THE RESERVE AT CORRAL BLUFFS SUBDIVISION

FILING NO. 3 Construction Drawings El Paso County, Colorado

PCD File No. SF20-7

SHEET: C1

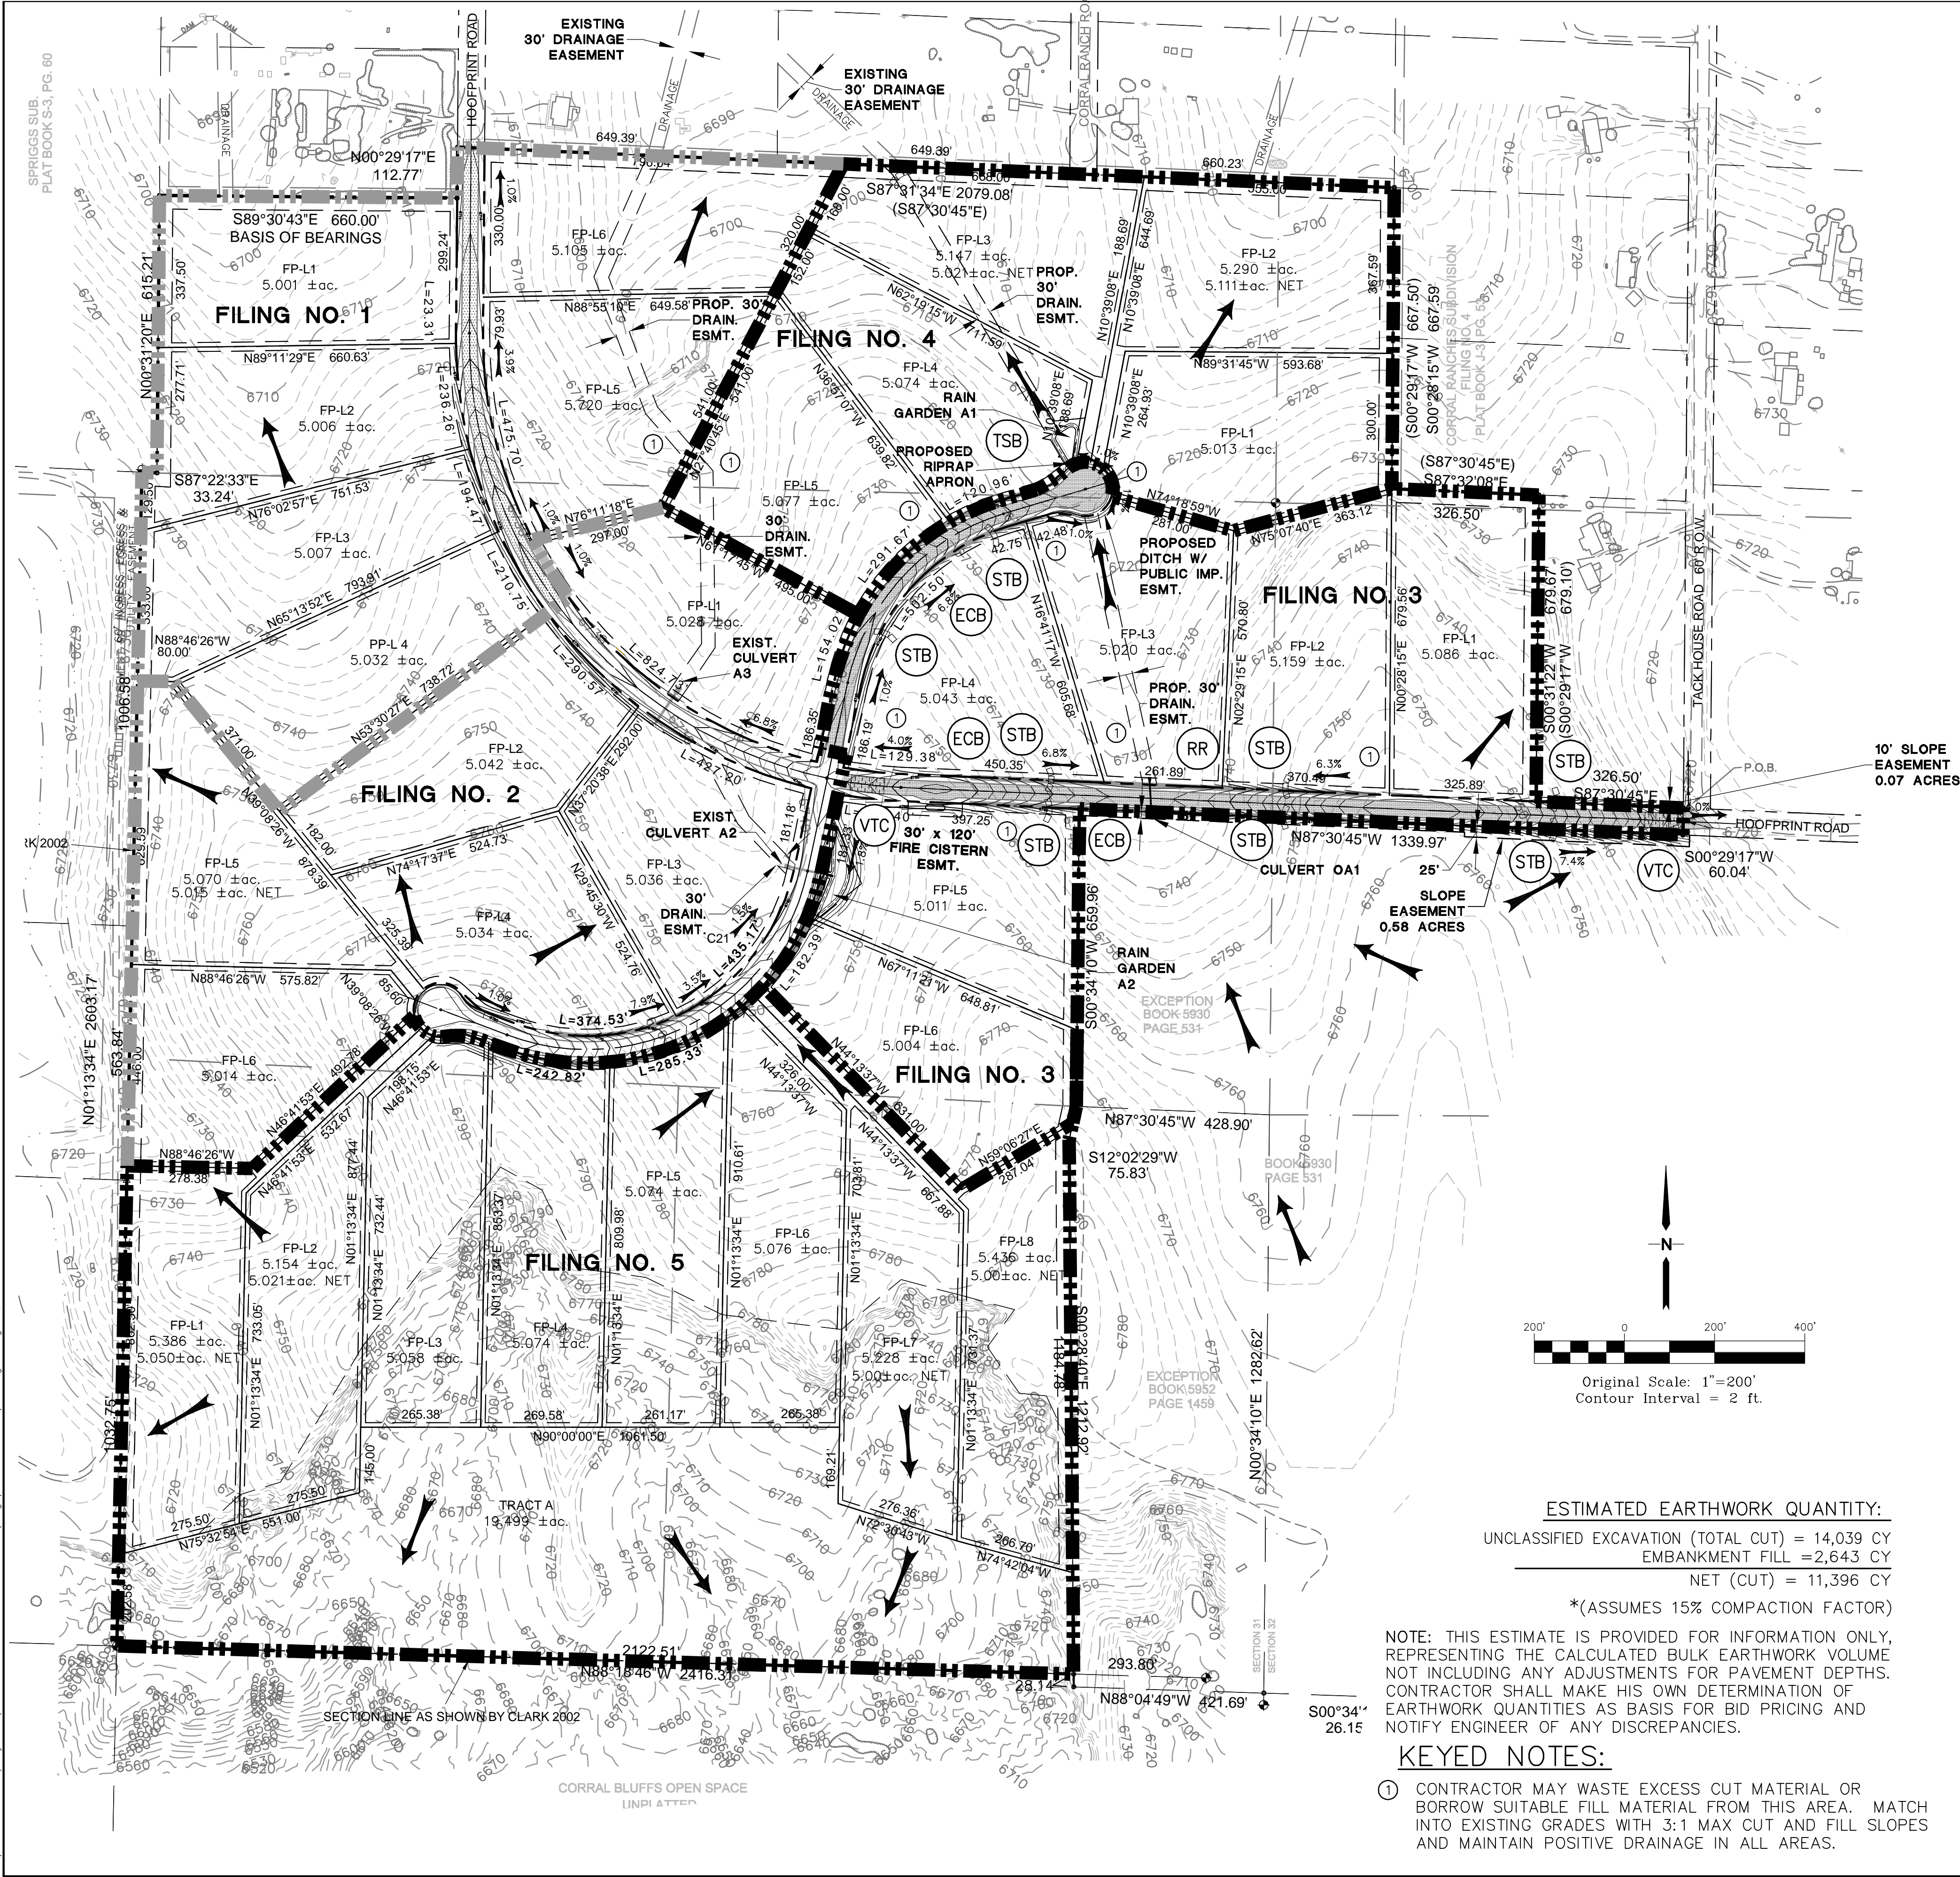
Disturbance is over 1 acre. Need temporary sediment basin to treat stormwater. Unresolved.

You will need a temporary sediment basin at the start of construction -- prior to the installation of the rain gardens.

Add temporary sediment basin to BMP Phasing
 Unresolved.
 Add rain garden construction to BMP Phasing

Add a note about the existing vegetation
 Add a note that no dedicated asphalt or concrete batch plants are planned on-site.
 Add a note stating that contractor shall update and annotate the SWMP Maps to show the location of the construction trailer, stabilized staging area, CWA, and other items as these locations are determined on site.
 Unresolved.

Provide erosion control blankets
 Provide erosion control blankets
 Unresolved.

provide the date and preparer of the soils report
 Unresolved.
